From: Ian Stocks [REDACTED] **On Behalf Of** FRS Water and Access
Sent: 06 August 2021 09:50
To: Planning.Responses <Planning.Responses@arun.gov.uk>
Subject: Planning consultation - F/7/21/PL Wicks Farm Ford Lane Ford BN18 0DF

Having viewed the plans for planning application F/7/21/PL, the nearest fire hydrant to the glasshouse is 200 metres away, over 100 metres more than the required 90 metres. Should an alternative supply of water for firefighting be considered it will need to conform with the details identified in Approved Document – B (AD-B) Volume 1 2019 edition: B5 section 14.

Drawing Title
Proposed Site Extension

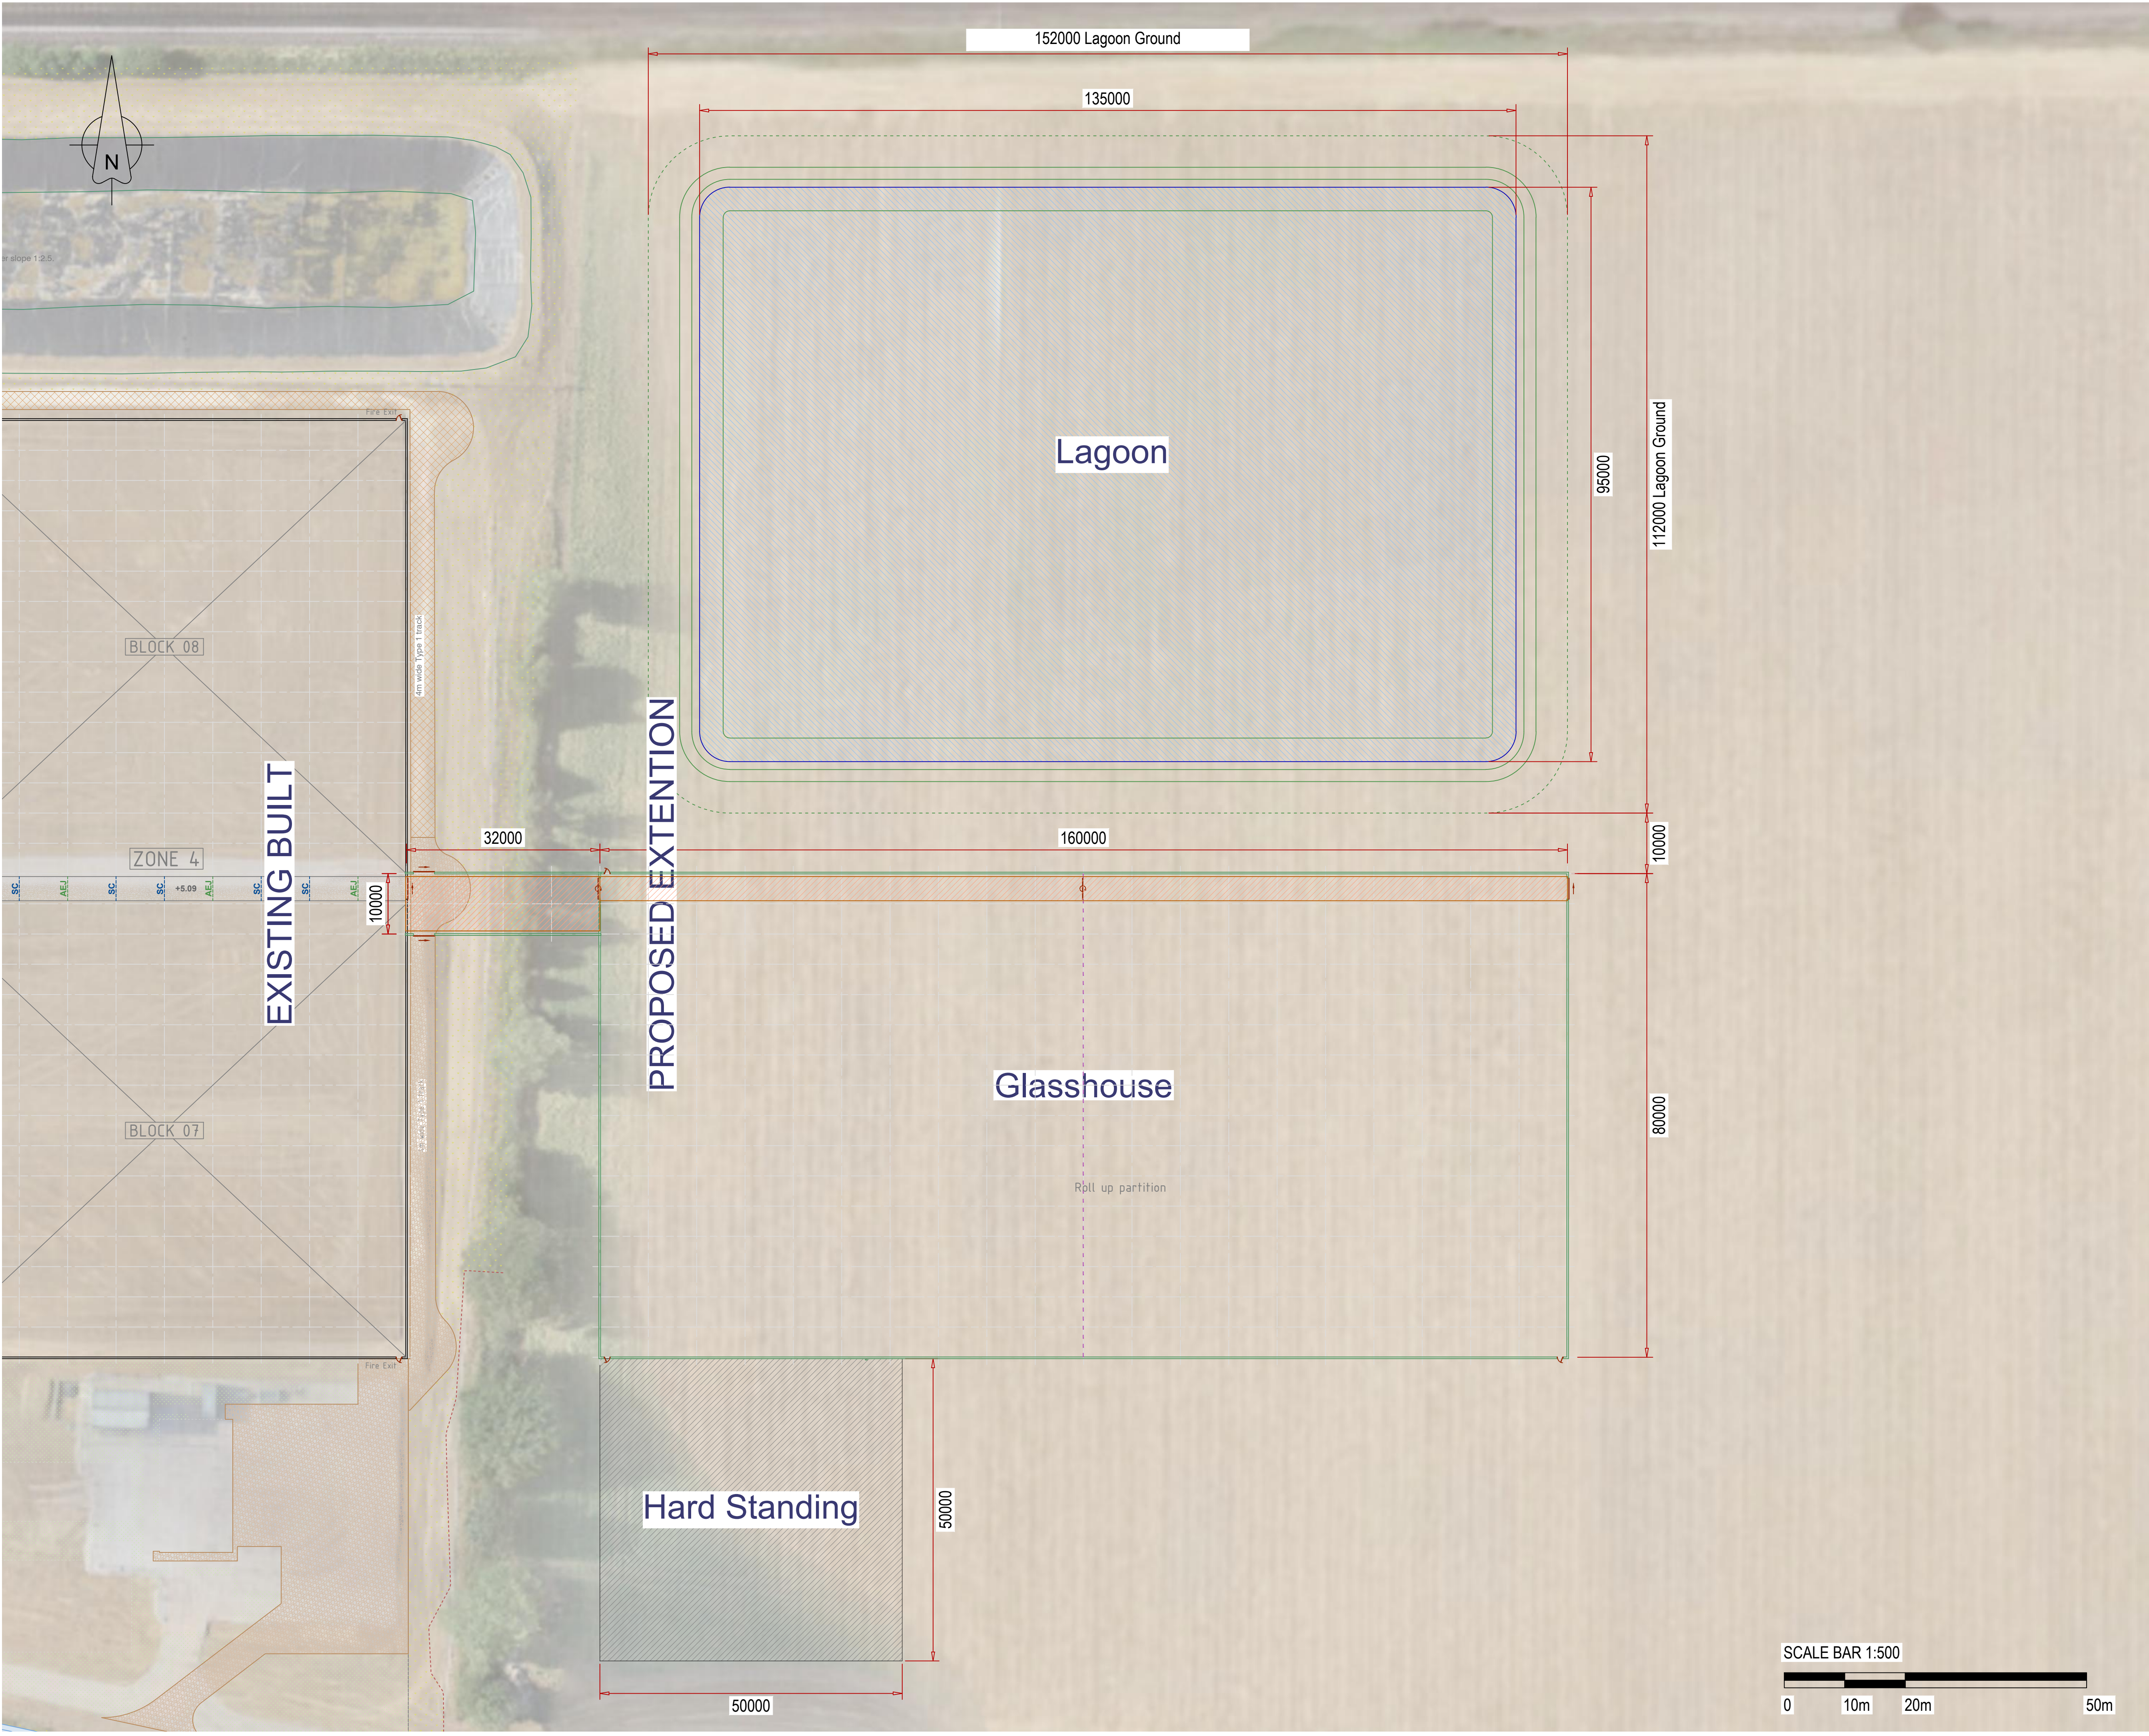
The access route to the glasshouse will also need to comply with AD-B Volume 2: B5 section 15, the access track needs to be 3.1 metres between a gateway and 3.7 metres between curbs, it is unclear from the plans submitted if the required access width has been achieved to ensure a fire appliance would be capable of reaching this area.
